From: Simon Davis
Sent: 20 May 2019 16:14
To: Planning Scanning
Subject: FW: Y/9818/RES and Y/97/18/DOC

From: Luke Hart [REDACTED]
Sent: 17 May 2019 18:29
To: Laura Gibbons [REDACTED]
Cc: Kathryn Griffith [REDACTED]; Caroline Green [REDACTED]; Zoe Knott [REDACTED]; Ryan Saul [REDACTED]; Dorota Kaminska-Majkowska [REDACTED]; James Lawson [REDACTED]; Lance Else [REDACTED]; James Hammond [REDACTED]; Darren McArthur [REDACTED] >
Subject: RE: Y/9818/RES and Y/97/18/DOC

Comments on the revised drainage and landscape proposals:

BOVIS HOMES
scheme: Land off Burndell Road Yapton
client: Bovis Homes
drawing: Hard Landscape Proposals
date: Nov. 2018
scale: 1:200@A1
drawing no: BOV22172 12E sheet 4
drawn: AE checked: DKM

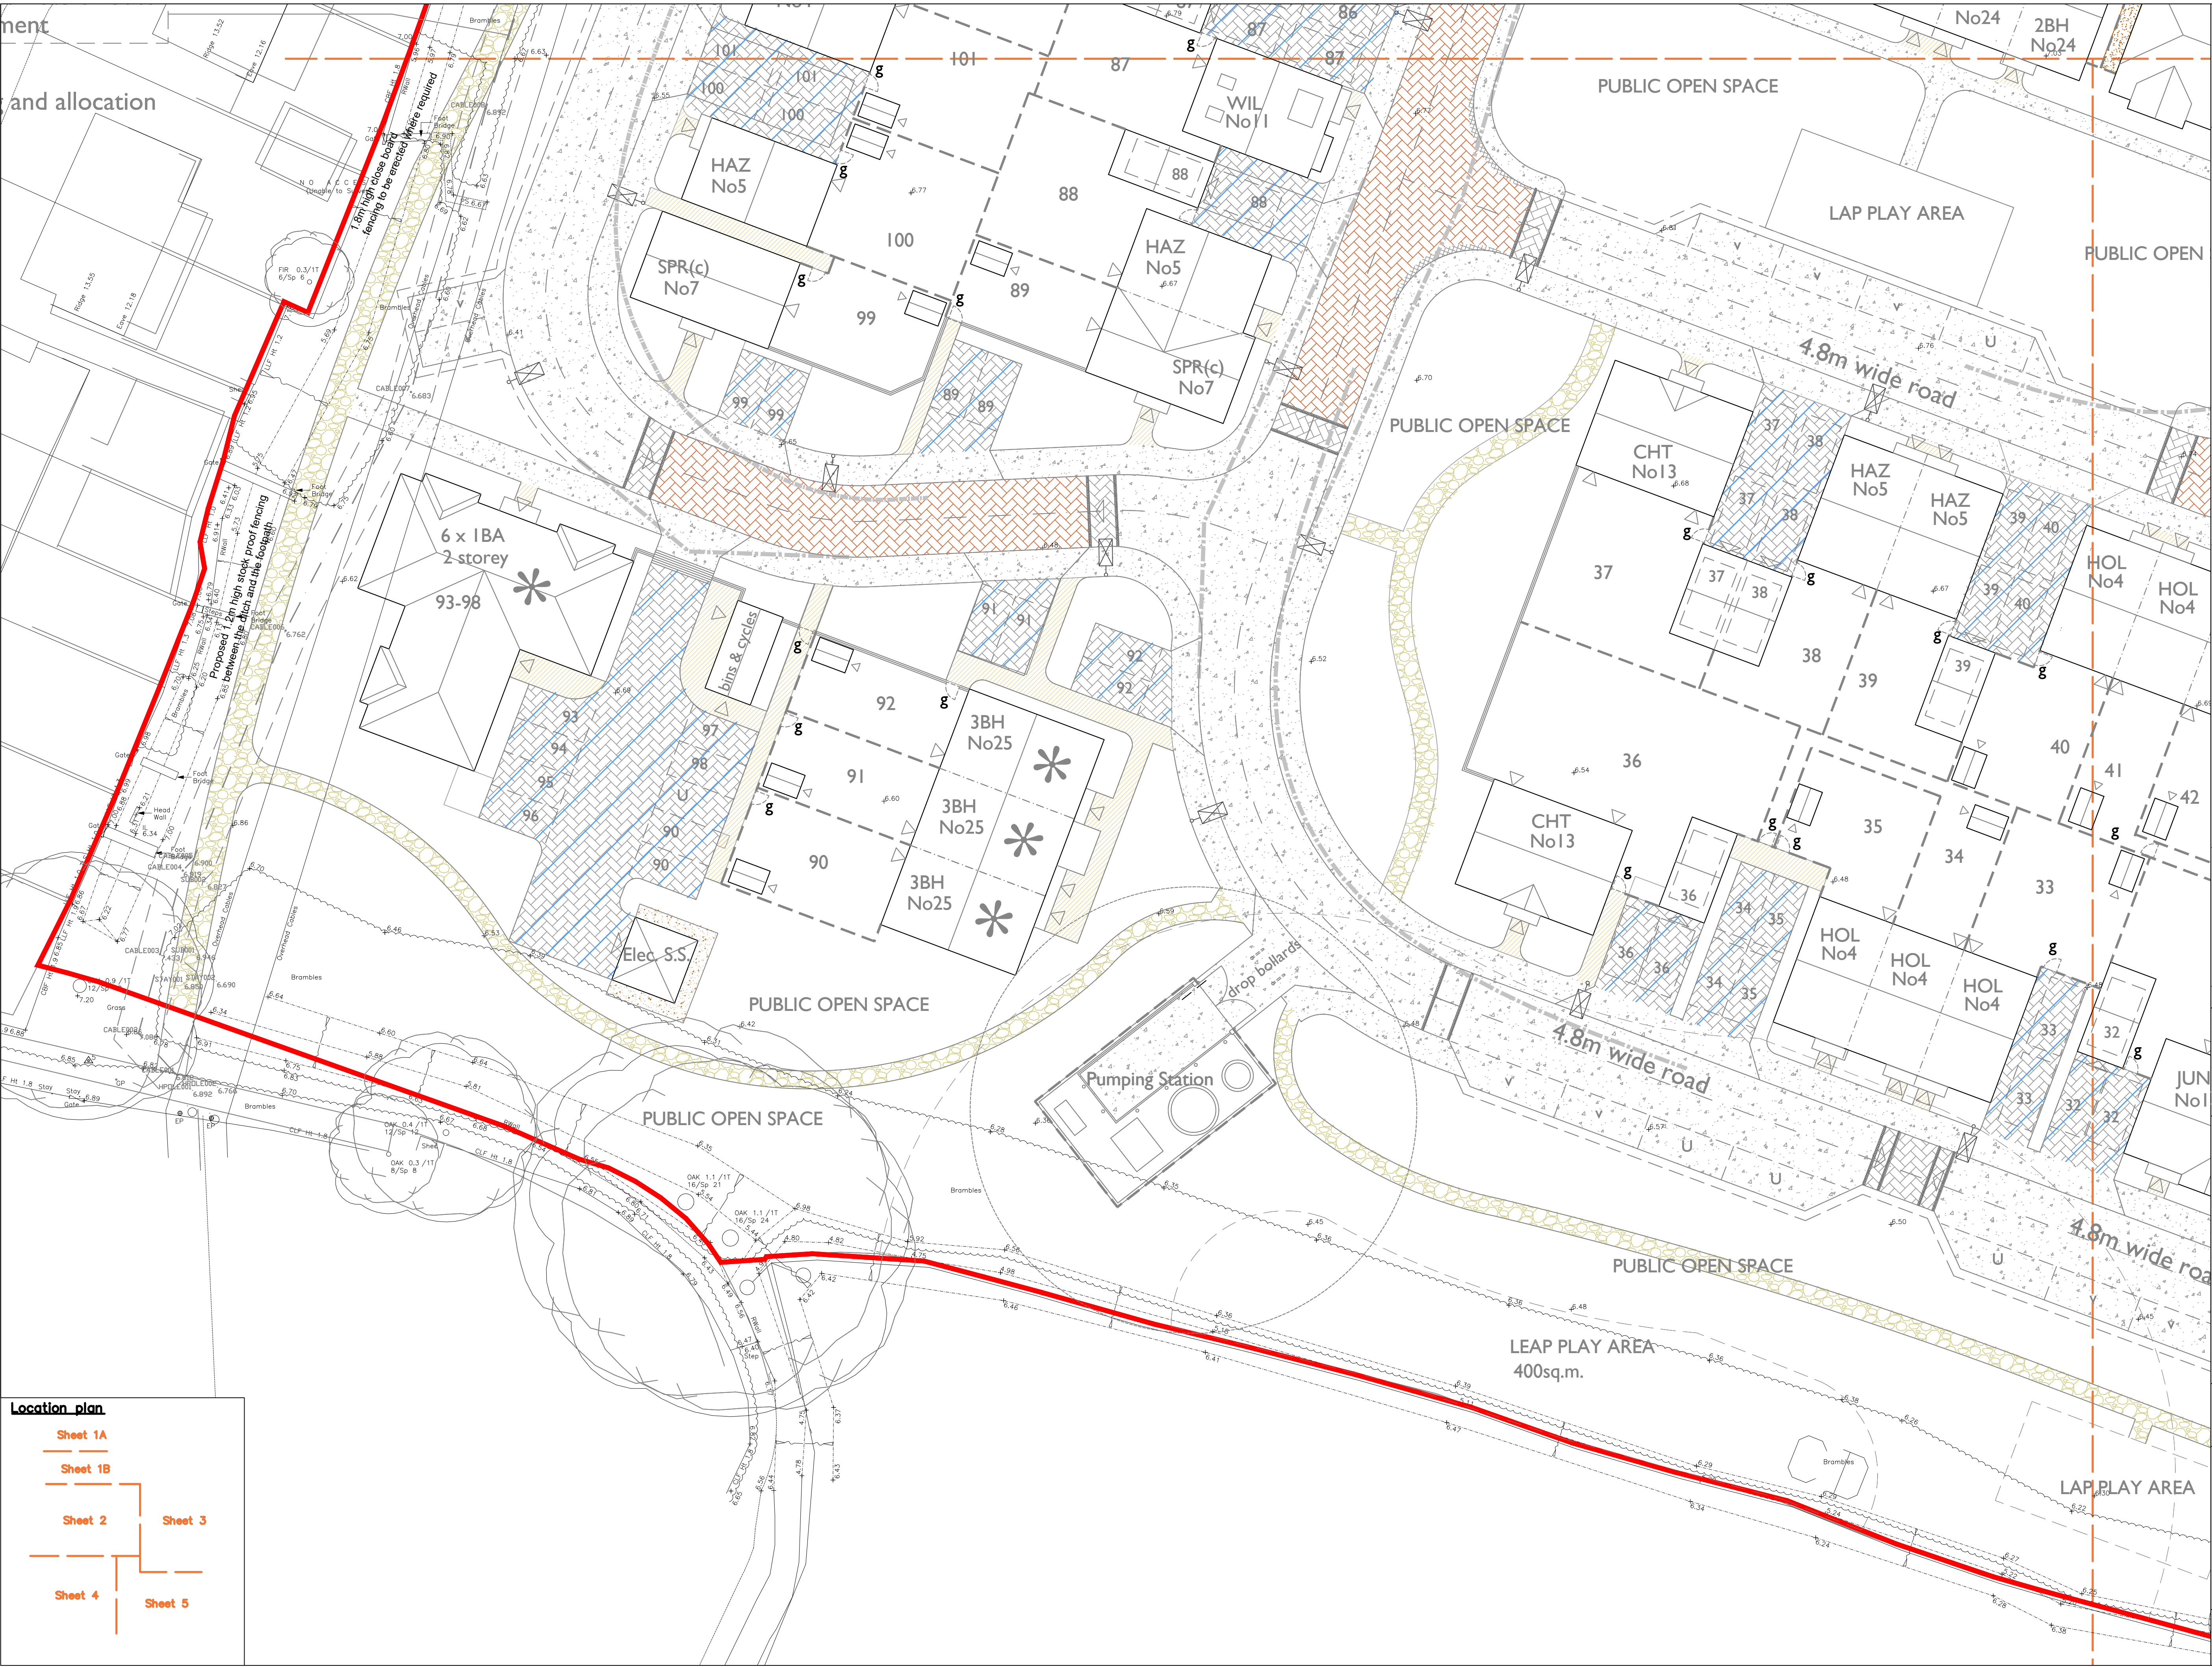
1. There are still trees proposed in close proximity to the southern-most attenuation tank. 2 no. trees close to this tank have been removed. Refer to updated ACD landscaping drawings. *On the ACD landscape drawing sheet 4 revision G there are trees in close proximity to the crate nearest the pumping station. Please can a plan be provided which shows both the proposed drainage and the proposed planting and associated potential root areas on the same drawing.*

1. ACD have shown tank footprints on their landscaping plans. Updated plans provided.
2. Pond sections with NAUE liner provided. Details provided. Tank flotation/groundwater assessment to be discussed as soon as possible.
